ATLASSIAN OFFICE AND HOTEL DEVELOPMENT SSD-10405 MOD 2 - APPLICANT RESPONSE TO SUBMISSIONS

The RTS request is in relation to a Section 4.55(1A) modification application (MOD 2) for the approved State Significant Development (SSD-10405) which approved an office and hotel accommodation development at 8-10 Lee Street, Haymarket.

1.1 FIGURE 1 - PROPOSED BASEMENT LEVEL 2 PLAN (CONTINUED)

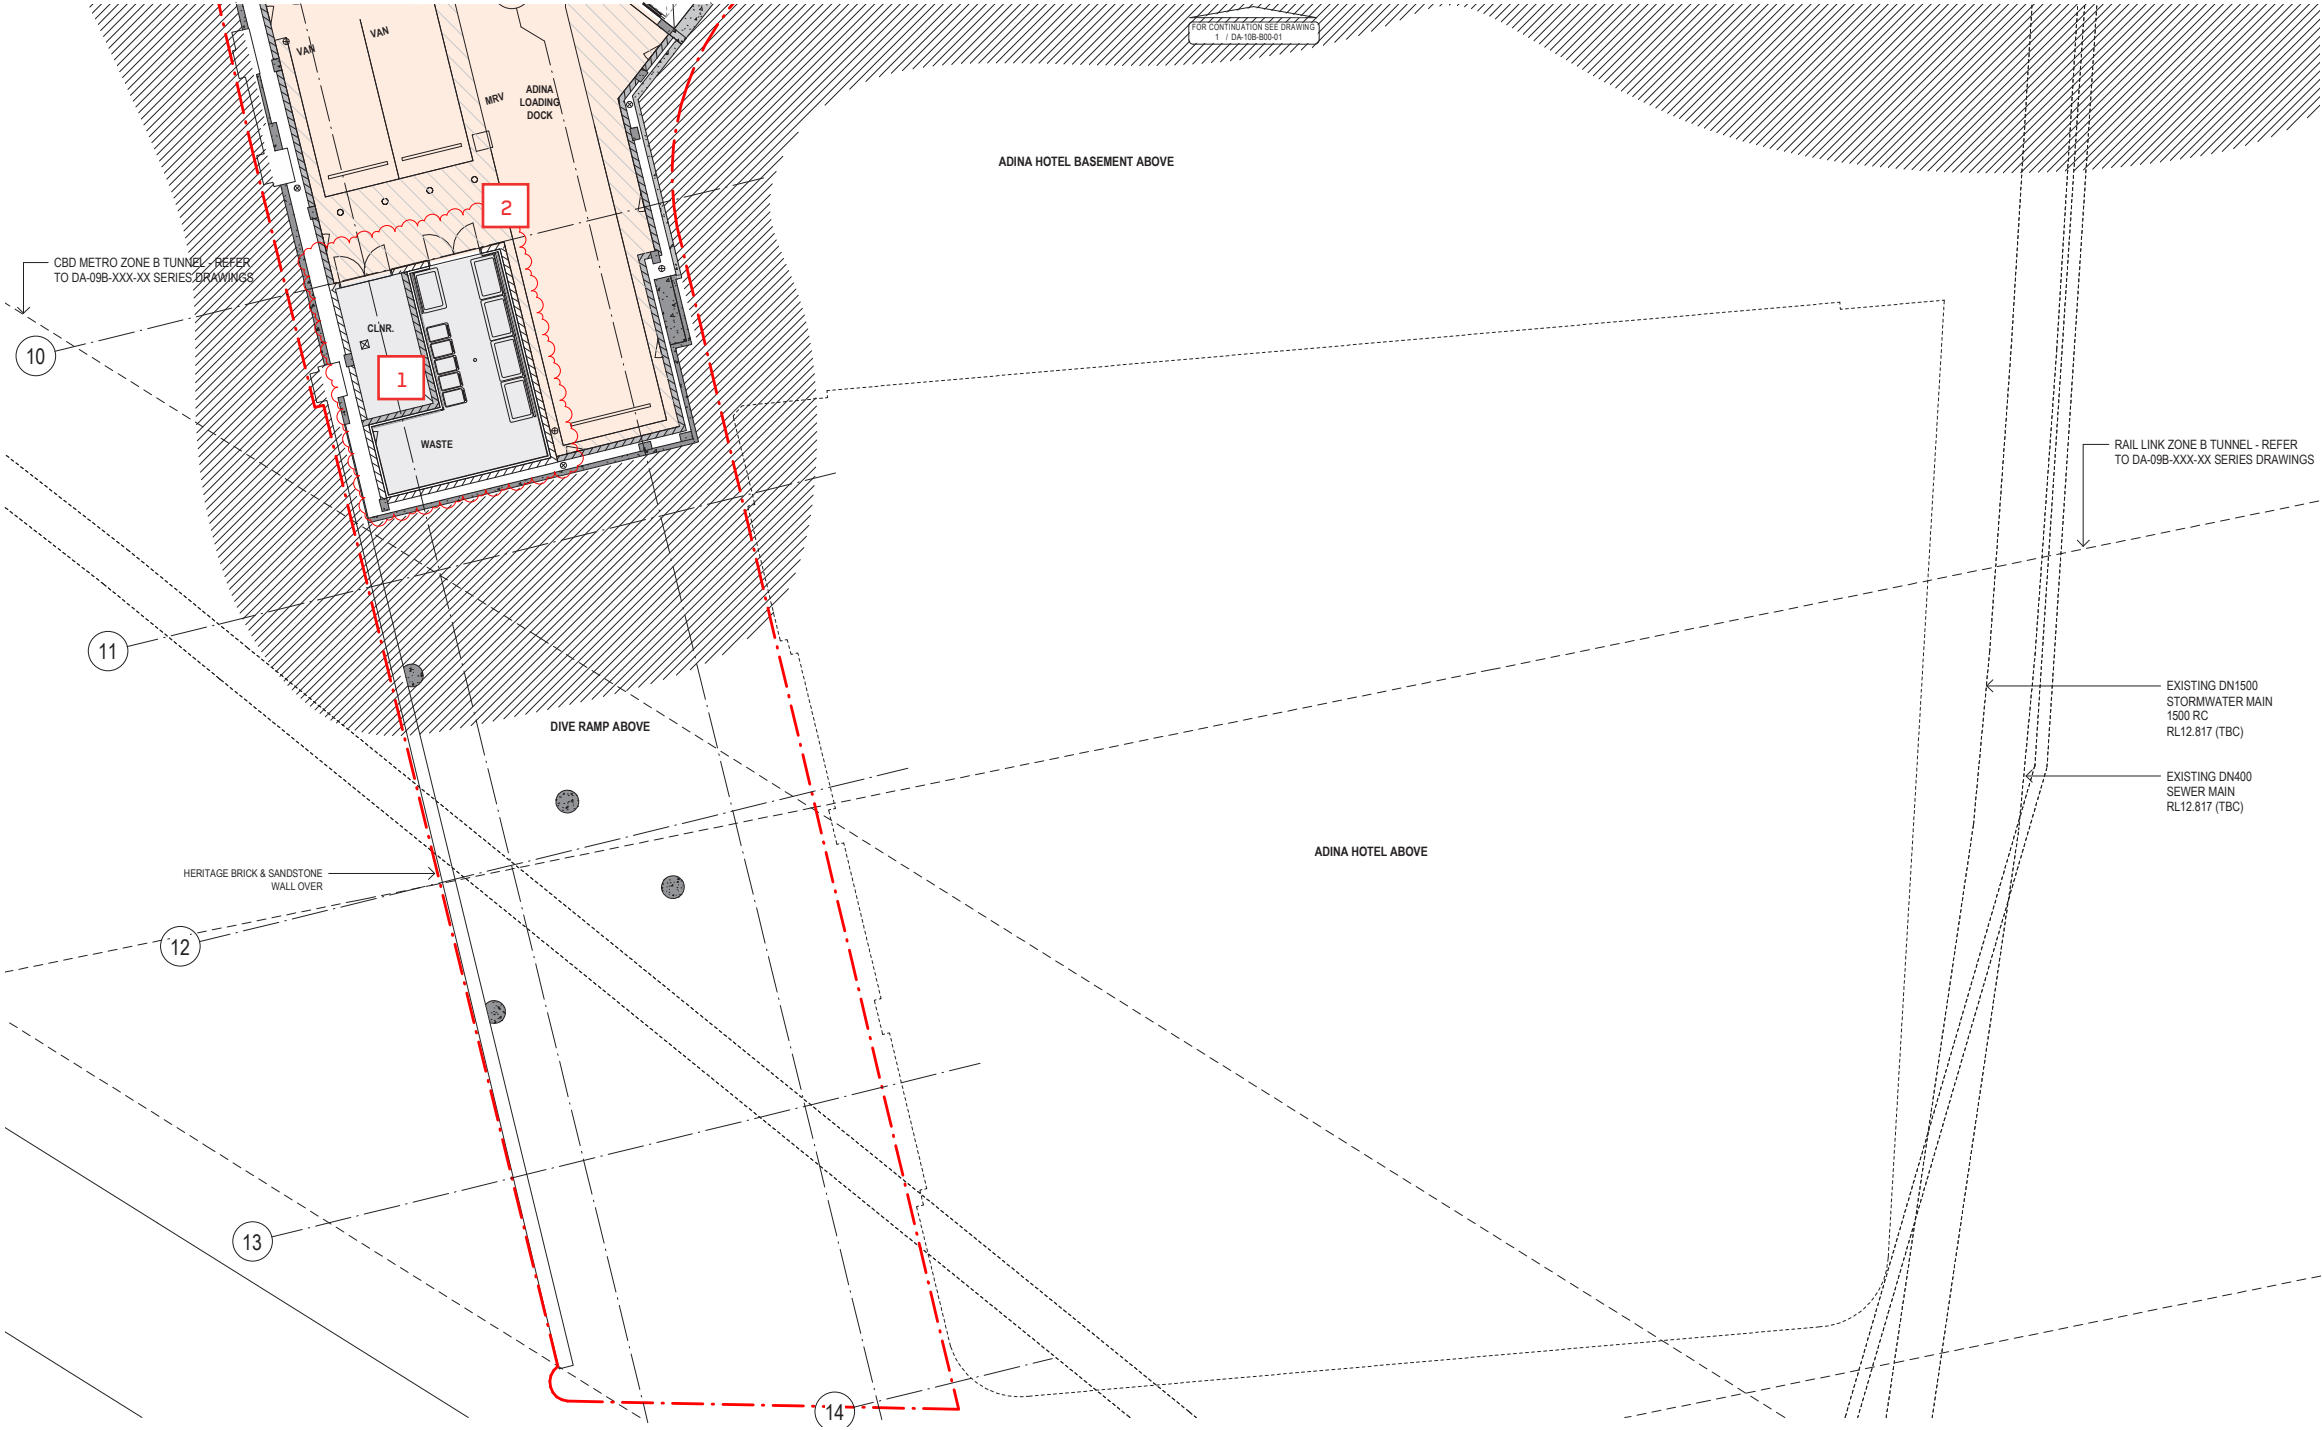
Issue	Response
City of Sydney	
<p><u>Waste Management</u></p> <p>The internal reconfiguration within the basement levels includes a reduction to the Adina loading area in front of the waste room at Basement Level 2. It is unclear how waste will be serviced in this area. Swept paths must be provided that demonstrate there is adequate space for a driver to enter and exit the vehicle and move the bins to the rear of the vehicle. It should also be noted that no bulky waste storage areas have been provided for the development. These should be provided in accordance with the City's Guidelines for Waste Management in New Developments 2018.</p> <p>It appears that a waste truck will need to back into the collection point for rear lift collection. A roller door should be considered along the wall where the truck backs into its loading dock to reduce bin movement and improve bin access to the rear of the vehicle.</p> <p>In accordance with Condition Nos. G37 and G38, an Operational Waste Management Plan must be prepared in consultation with the City prior to the issue of Occupation Certificate. At this early stage of the development, it should be noted that the current Waste Management Plan is not supported, and further information will be required in the future to address the following:</p>	<p>There is a total of 16m² and 4m² for bulky waste storage in the Atlassian and YHA waste rooms respectively. The TOGA/Adina waste room would accommodate a bulky waste storage area of 4m² if required. We note that the TOGA site is subject to a separate SSDA relating to its future redevelopment.</p> <p>The plan layout (AR-13B-B00-02) shown in the Waste Management Report prepared by GHD dated February 2022 shows a double door arrangement to the loading dock. This can be amended to a roller door arrangement if required, subject to architectural input.</p> <p>An Operational Waste Management Plan will be prepared in accordance with consent condition G37 and G38 prior to OC.</p>

Issue	Response
<ul style="list-style-type: none"> - Details of sweeping paths for each loading bay and clearance of 2 metres for loading. - Details on how vehicular movements will be minimised and whether all three sites will be serviced by the same waste contractor. It is the City's preference that each site requires general and recycling waste to be collected each day. - Specific details on collection times. - Greater detail on the uptake and management of onsite food processing. The current Plan only provides suggested approaches. - Whilst reference was made to the individual bailing of paper, cardboard and soft plastics in the Plan, no space is assigned for the storage of bailed waste or source separation bins for these individual waste streams. - The Plan outlines that organic food scraps are to be stored in 1100L waste bins. Due to weight issues and OH&S concerns, these bins should be a smaller size of 240L or less. 	<p>It is noted that the vehicle swept path analysis for Basement 2 was considered as part of the traffic impact assessment. On this basis, the existing Waste Management Report (GHD 2022) identifies that a two metre clearance would be available between the parking space and wall for the loading of bins where collection vehicles reverse into parking spaces for waste collection using rear loader waste collection vehicle.</p> <p>The collection frequency assumed for the waste storage requirement estimate was based on daily collection. Specific details on collection timing and arrangement is pending engagement of a waste contractor.</p>
